KITITITAS COUNTY COMMUNITY DEVELOPMENT SERVICES

RE: McIntosh CUP Application 1,2,3

We have completed a careful review of your application for a Conditional Use Permit to excavate, screen and remove rock and dirt from the site located along SR-97. It has been determined that additional information is needed in order to fully review your application, and route it for SEPA notice. As outlined below, the following information must be provided to our office in order for a Determination of Completeness to be issued and the application to be processed:

PARCEL A-3
BOOK 24 OF SURVEYS
AT PAGE 230
TAX PARCEL NO. 18-18-08020-0003
1"=200'

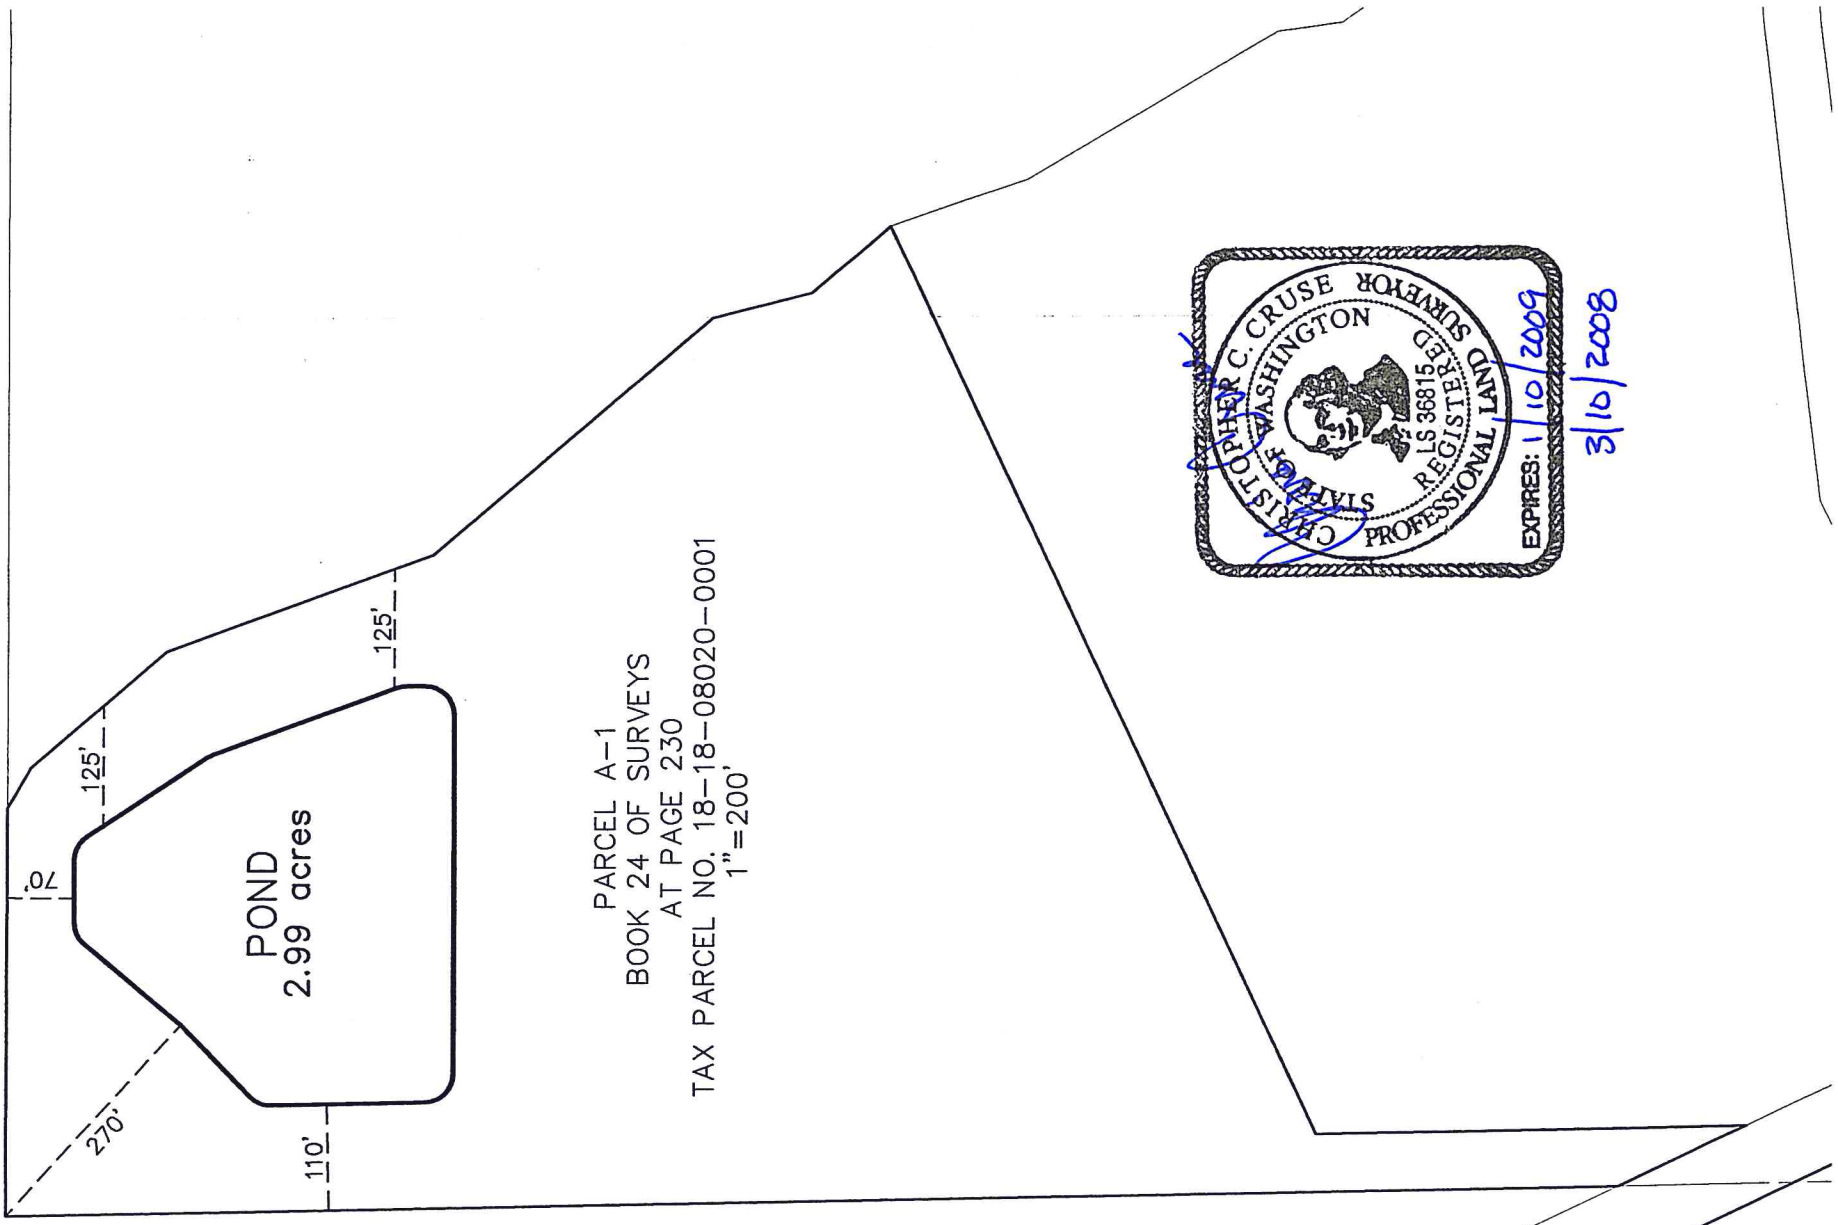
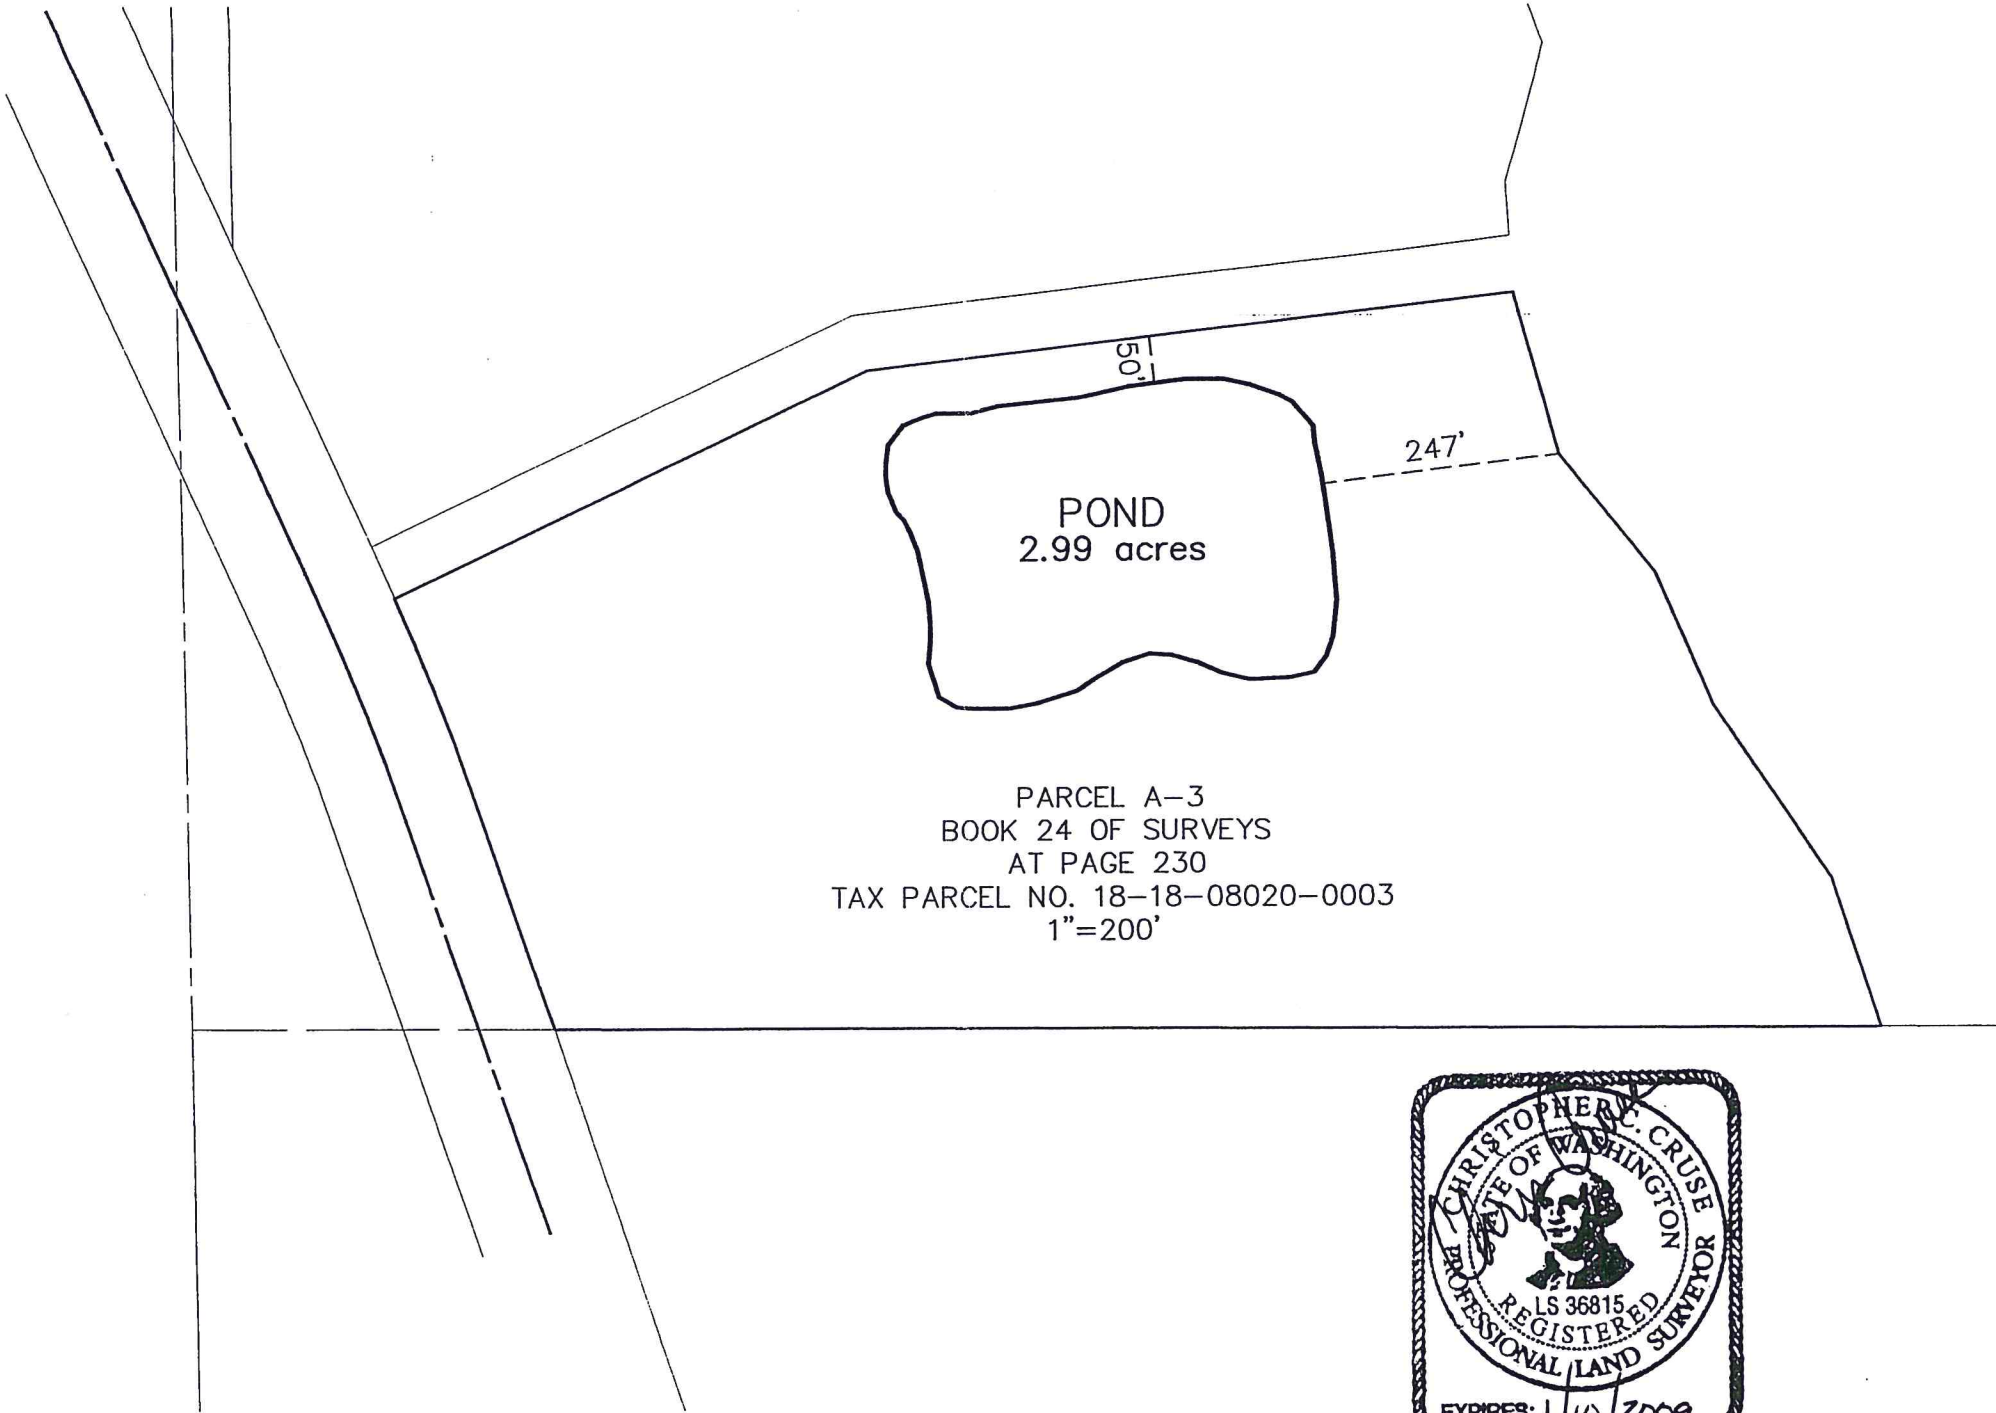
The site plan is incomplete. Please provide a new plan for each application showing the following:

- Buildings(One parcel has a structure on it, please provide the location on the site plan)
- Points of Access
- Roads and Parking Areas
- Areas to be cut and or filled depicted by a cross section
- Streams, Gullies, Cliffs etc.(Dry Creek runs thru all three parcels. It is a class 3 stream with 20-50 ft setbacks)
- Wetlands
